**61 MOBBS LANE, EPPING
RESIDENTIAL DEVELOPMENT**

Reference is made to The Department of Planning's correspondence dated 27 September 2010 (Ref: MP10_0107), regarding the above mentioned Development Application referral to the Roads and Traffic Authority (RTA) for comment in accordance with Clause 104 and Column 2 of Schedule 3 of State Environmental Planning Policy (Infrastructure) 2007. The Sydney Regional Development Advisory Committee (SRDAC) considered the traffic impact of this application at its meeting on 20 October 2010.

22 October 2010

1 SITE PLAN
1 : 250

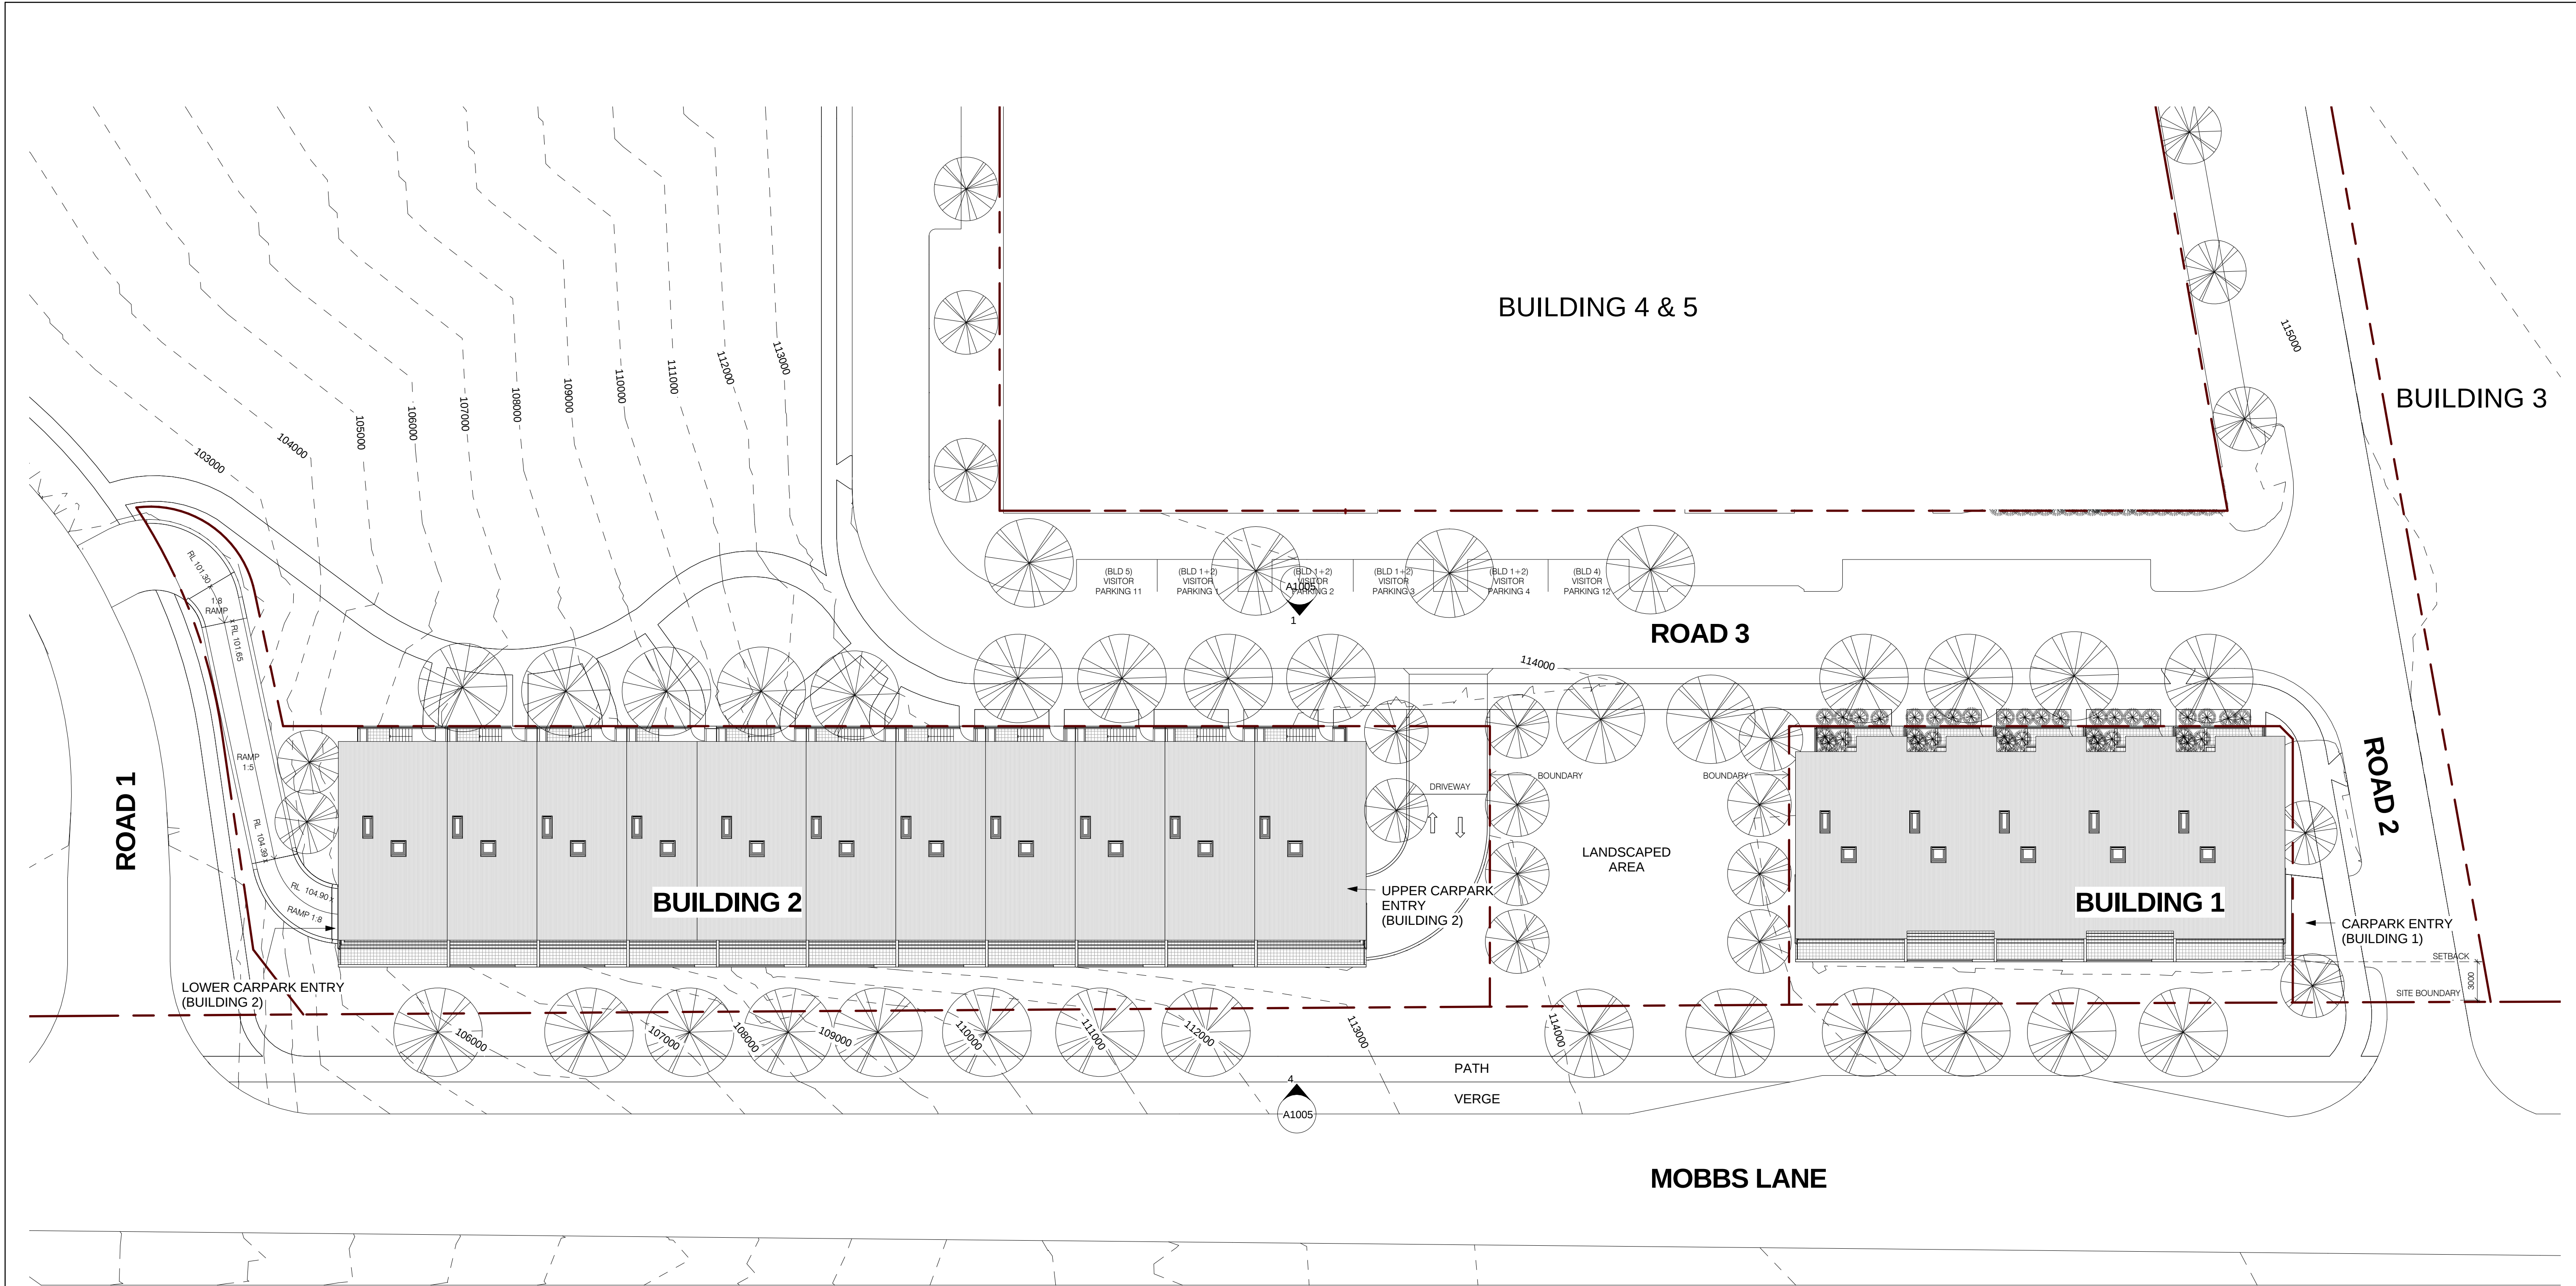
1. The road works on Mobbs Lane including the right turn bay into Road One, the bus bay, pedestrian refuge and footpaths shall all be constructed in accordance with the current standards and shall be fully operation prior to the release of any Occupation Certificates associated with Stage 1 of the development.

2. The bus bay on Mobbs Lane should be designed and constructed to accommodate the largest bus proposed to use the bus bay.
3. The developer shall be responsible for all public utility adjustment/relocation works, necessitated by the above work and as required by the various public utility authorities and/or their agents.

6. The swept path of the longest vehicle (including garbage trucks) entering and exiting the subject site, as well as manoeuvrability through the site, shall be in accordance with AUSTROADS. In this regard, a plan shall be submitted to the Department of Planning for approval, which shows that the proposed development complies with this requirement.
7. Resident parking should be clearly signposted at entry to car parking areas.
8. All demolition and construction vehicles are to be contained wholly within the site and vehicles must enter the site before stopping.
9. All works/regulatory signposting associated with the proposed development are to be at no cost to the RTA.
